**RE: 12<sup>th</sup> Street Road Diet (CPN 718780)**  
**Final Drainage Report**  
**Engineer's Stamp Date: 06/19/24**  
**Hydrology File: H13D120**

**RE: 12<sup>th</sup> Street Road Diet (CPN 718780)**  
**Preliminary Drainage Report**  
**Engineer's Stamp Date: No Date**  
**Hydrology File: H13D120**

Based upon the information provided in your submittal received 03/12/2024, the Final Drainage Report **is not** approved for Work Order. The following comments need to be addressed for approval of the above referenced project:

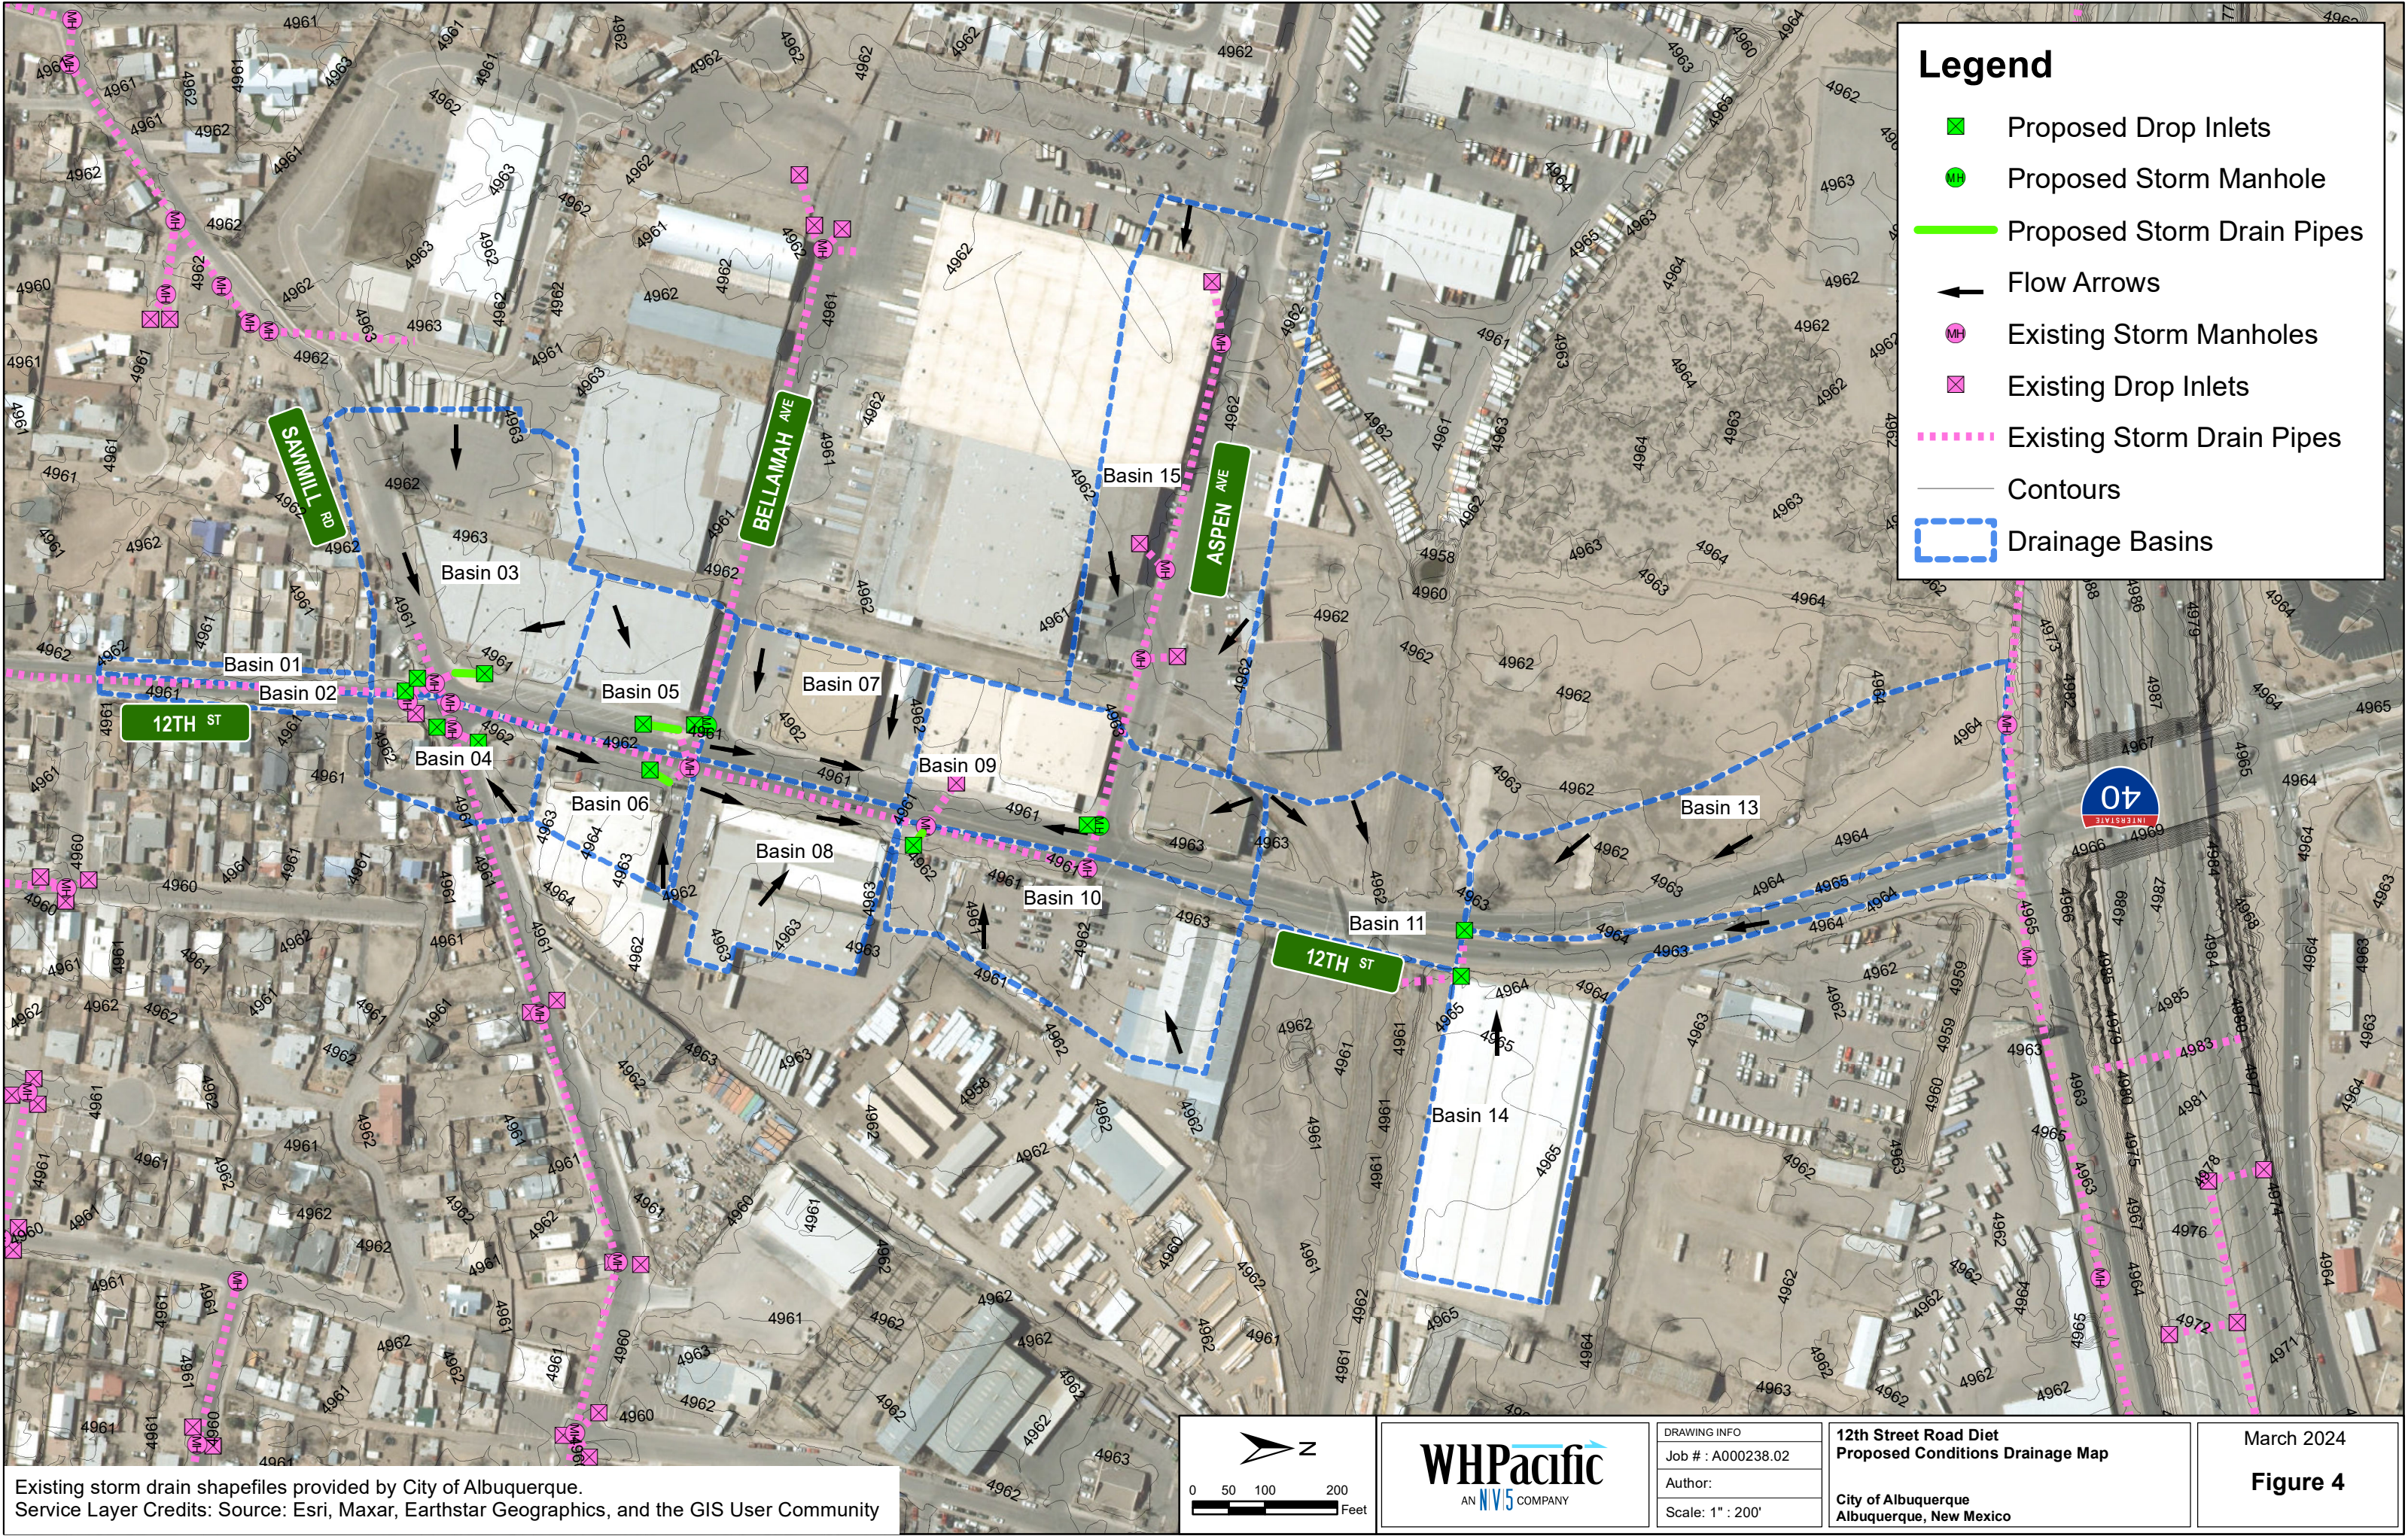
1. Please provide an engineer's stamp with a signature and date. **Done**
2. It appears that the drainage area for Bellamah Ave is missing in both the existing conditions and proposed conditions drainage maps. **The Bellamah storm water flow rate had been taken from the 60% design for and included in this analysis, but that was not evident in this report. The drainage basins and hydrology from the Preliminary Drainage Report prepared for Bellamah (City Project 7703.72) have now been included on the basin map and hydrology. The storm runoff from Bellamah is included in the 12th Street storm drain. The basin divide is correct as shown in Basin 05 which is a high point in Bellamah Avenue – stormwater flows from the basin 5 divide west to a small sag in Bellamah Avenue that will be held in the future roadway improvement design. See revised figures and additional hydrology added in the Appendix.**
